Rezoning Transportation Analysis

Petition Number: #2022-079

From: Jake Carpenter, PE

Revision Log:

RZ - 200

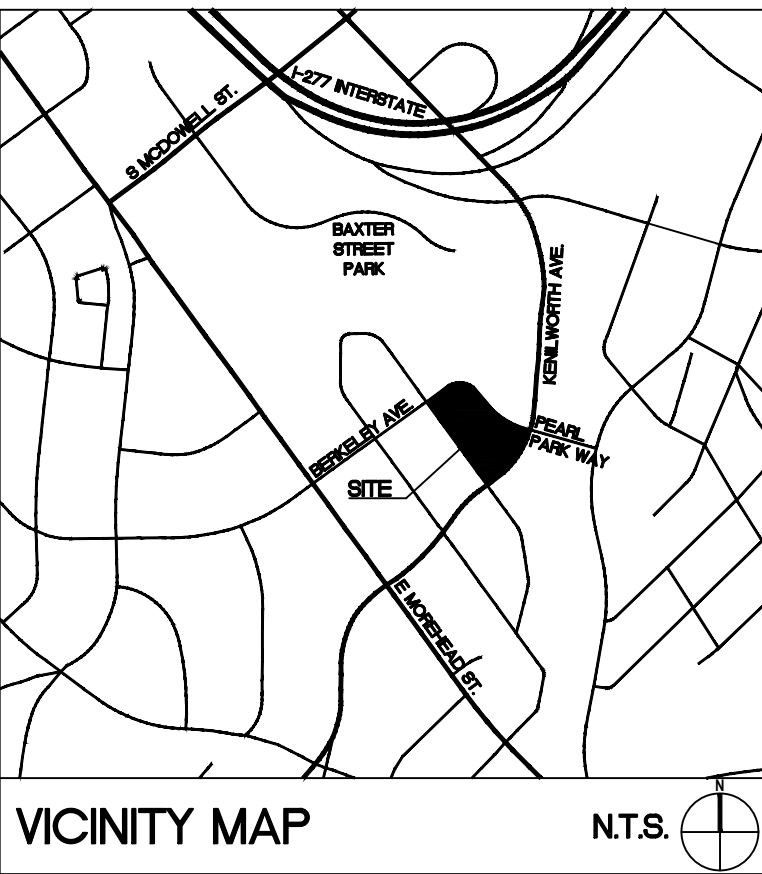
~~**Outstanding comment 01-24-24:** Density changed awaiting updated TIS addendum.~~
